Rezoning Transportation Analysis

Petition Number: 2023-095

Date	Description
9-28-23	First Review (IW)
11-27-23	Second Review (ME)

**C200**

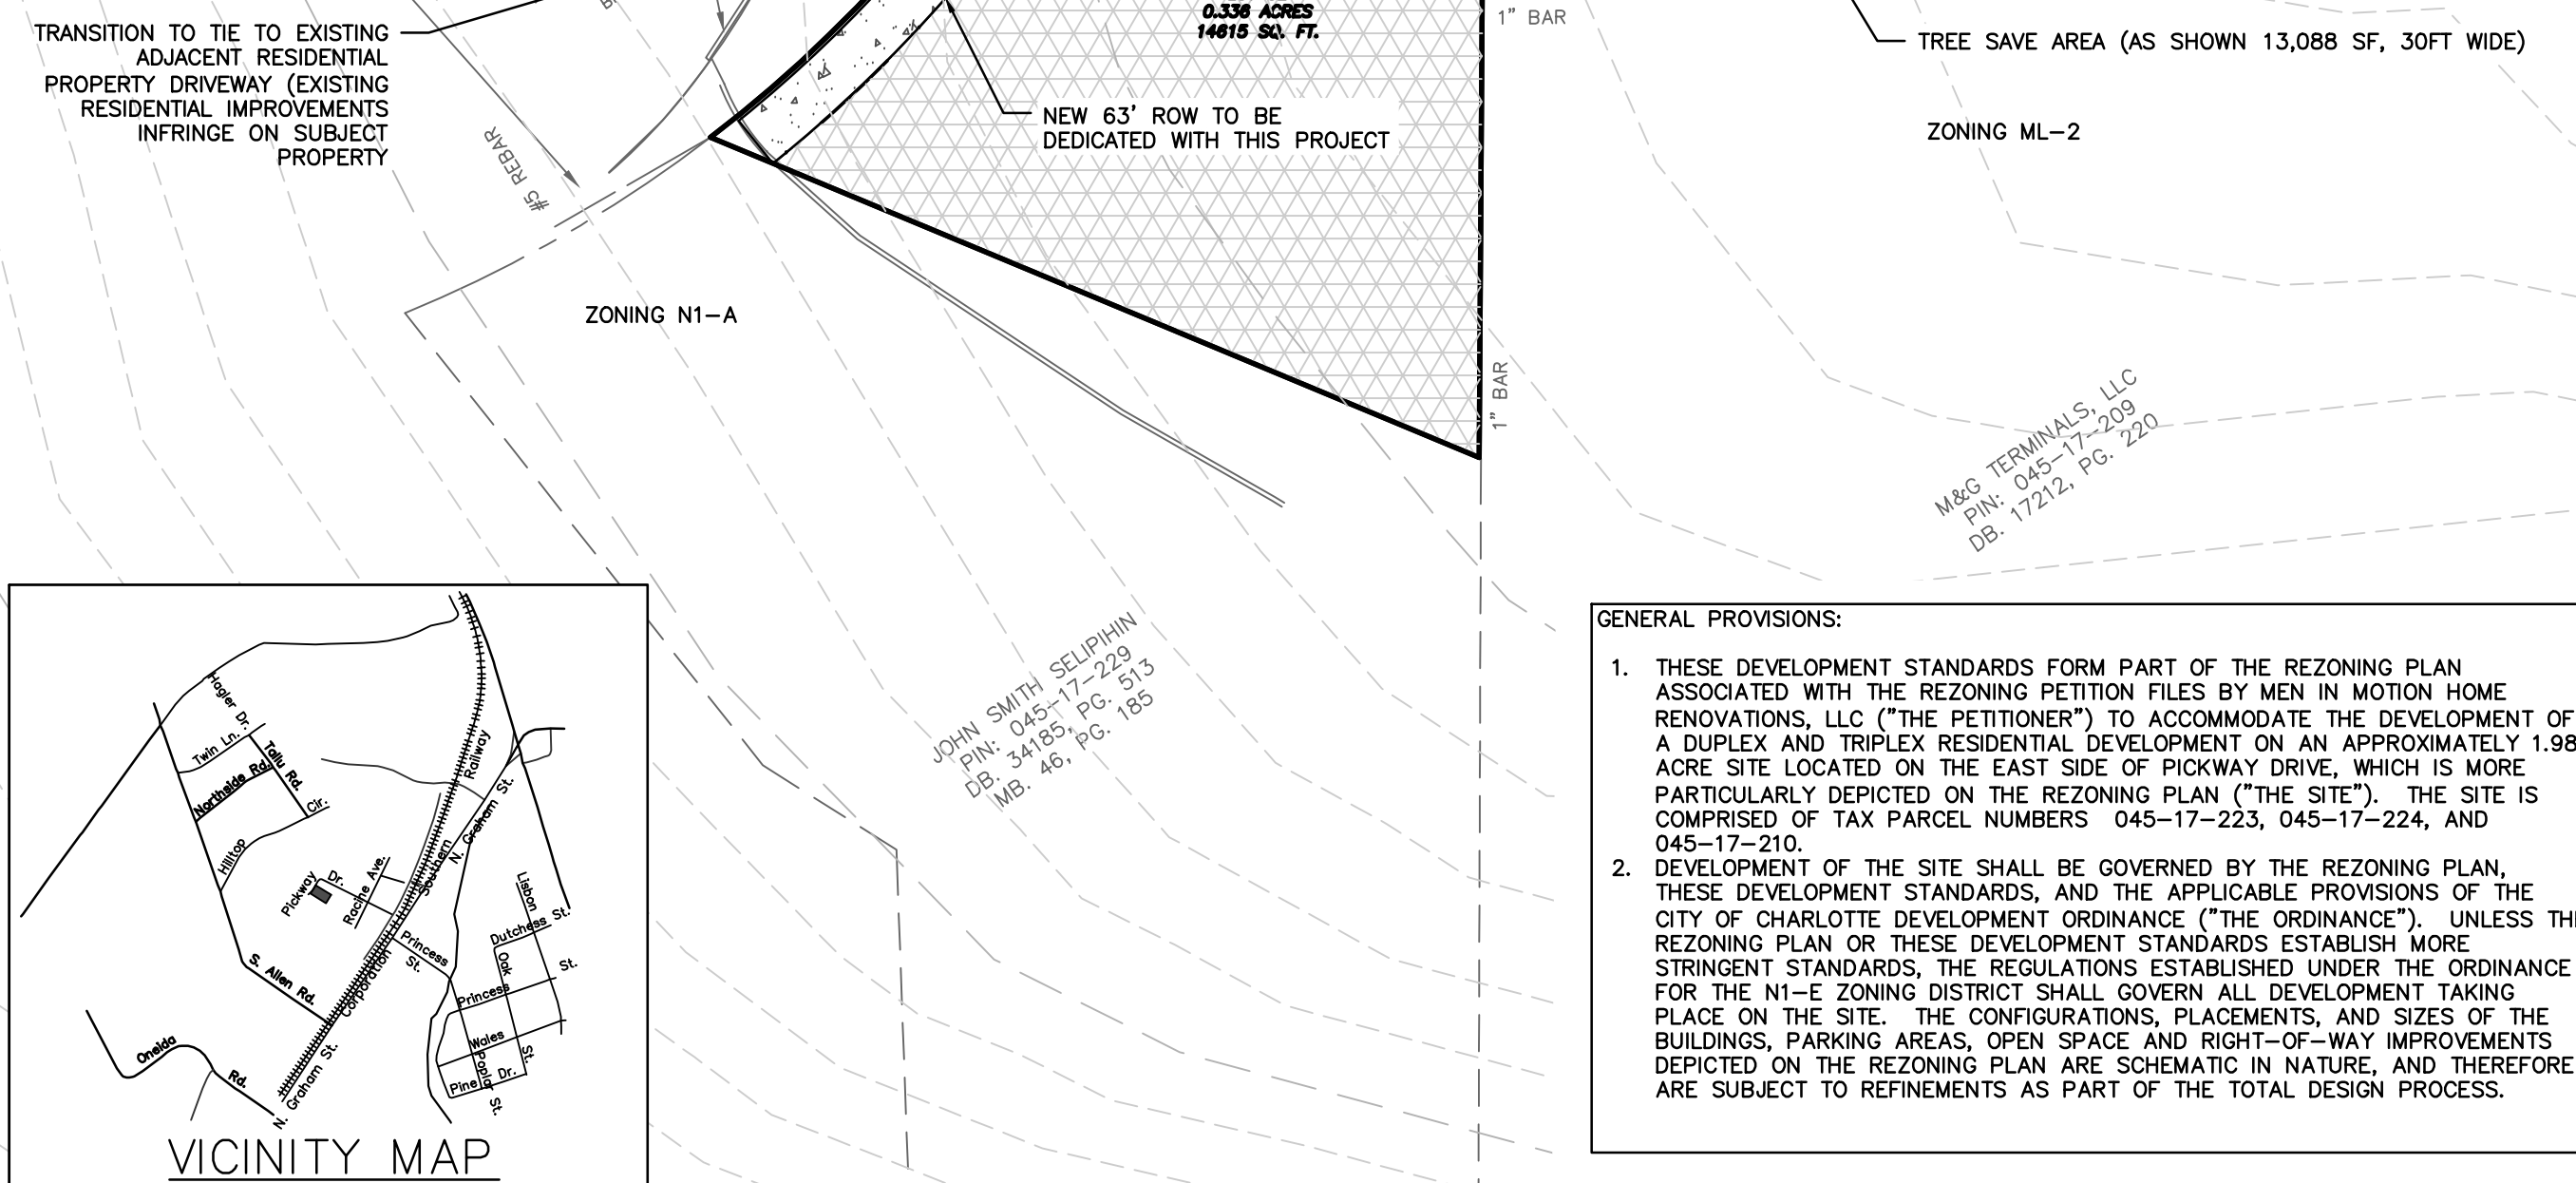
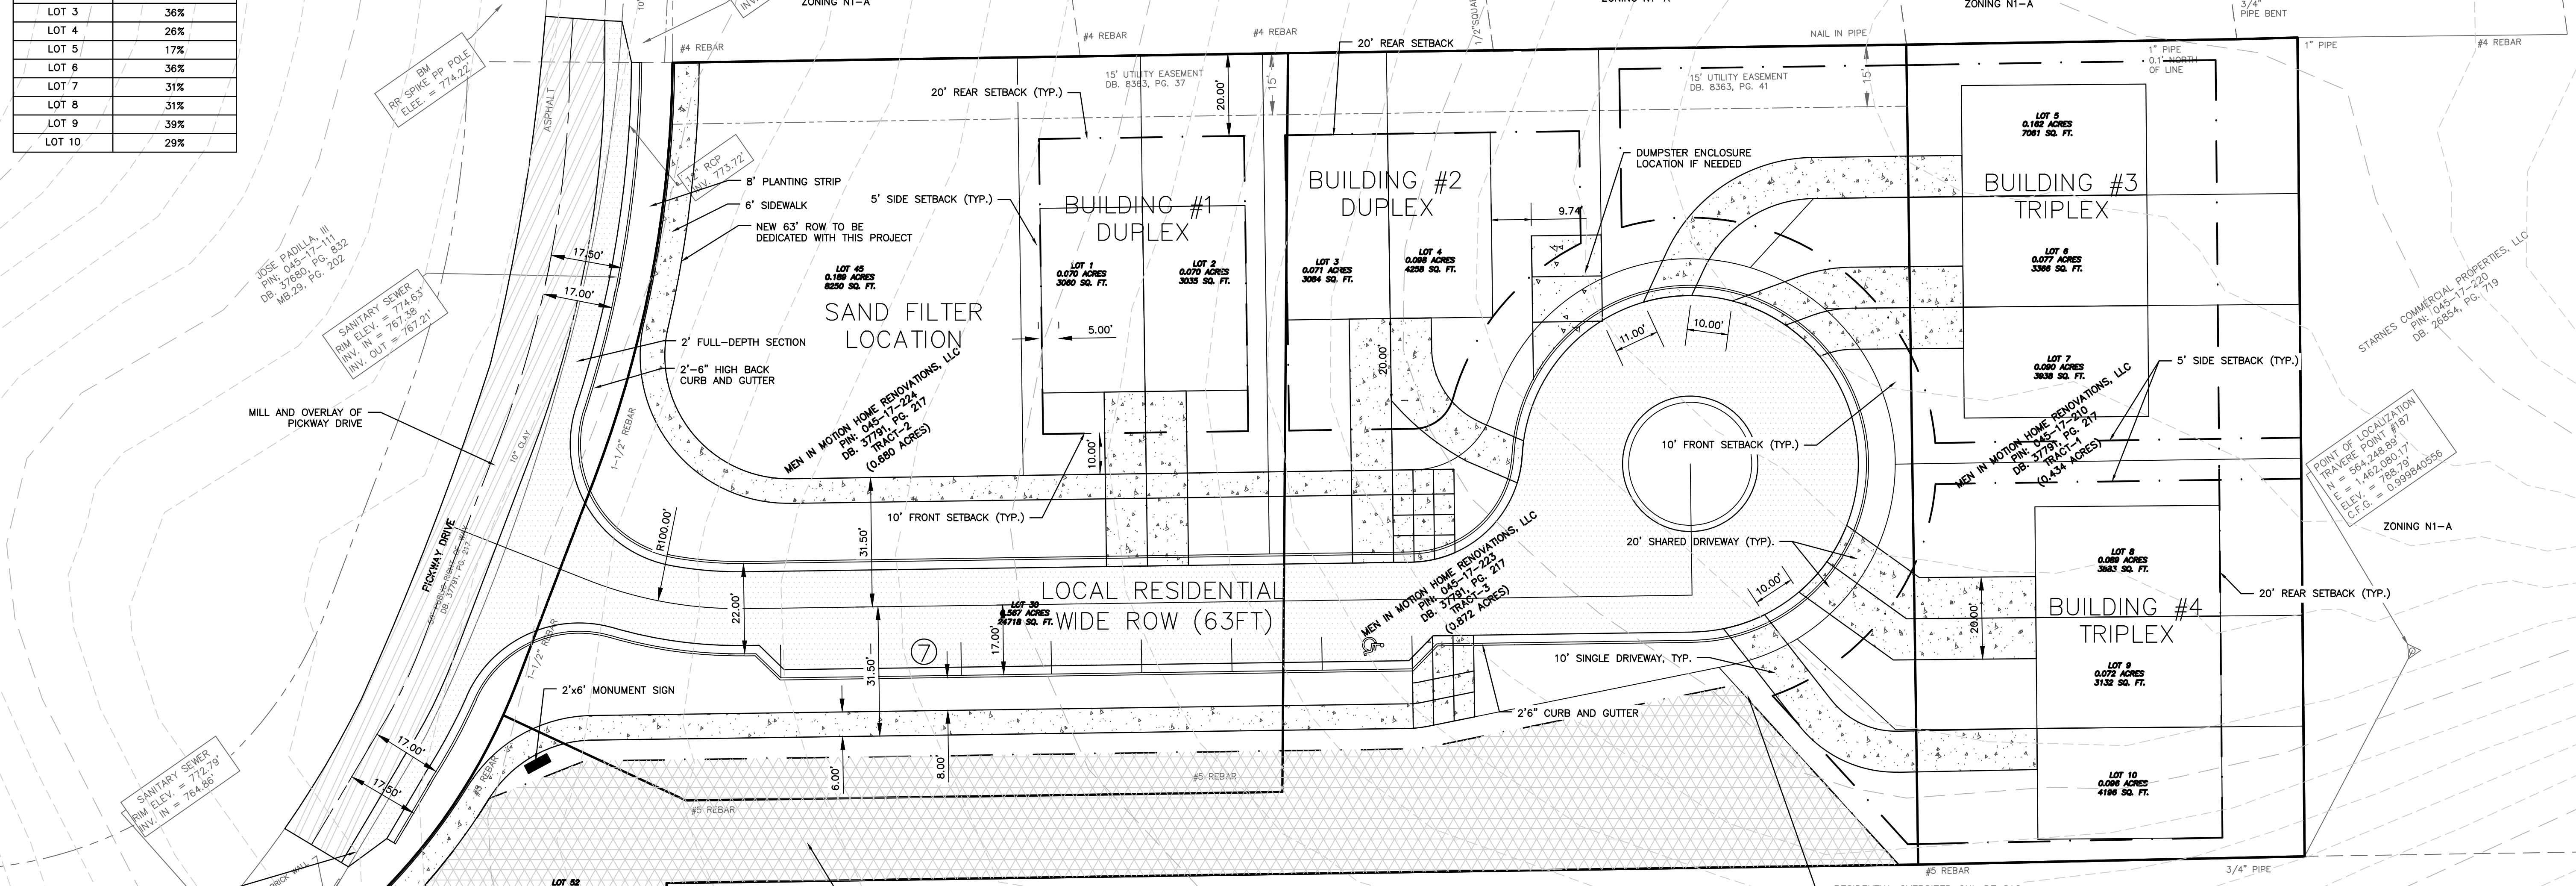
3. Revise site plan and conditional note(s) to commit to dedicate 31.5 feet of right-of-way from the road centerline. The site plan shall label and dimension the right-of-way from the road centerline.

Comment 11-27-23: Please revise site plan and conditional note to commit to mentioned right-of-way dimension with labeling and dimensioning from the roadway centerline.

5. Revise site plan and conditional note(s) to commit to an 8' planting strip and 6' sidewalk per the CLDSM U-03A2 along Pickway Drive per UDO Article 33.

Comment 11-27-23: Please revise conditional note(s) to commit to an 8' planting strip and 6' sidewalk per the CLDSM U-03A2 along Pickway Drive per UDO Article 33.

6. Revise site plan and conditional note(s) to commit to providing an ADA on-street parking space to meet Federal ADA guidelines.

Comment 11-27-23: Please revise conditional notes to commit to ADA parking..

7. CDOT requests petitioner to revise site plan and conditional note(s) to commit to milling and overlaying the entire road instead of half, as the existing road is substandard and half milling may create grade issues at the tie-in between pavement sections.

Comment 11-27-23: Please revise conditional note(s) to commit to milling and overlaying the entire section of Pickway Drive across development frontage.
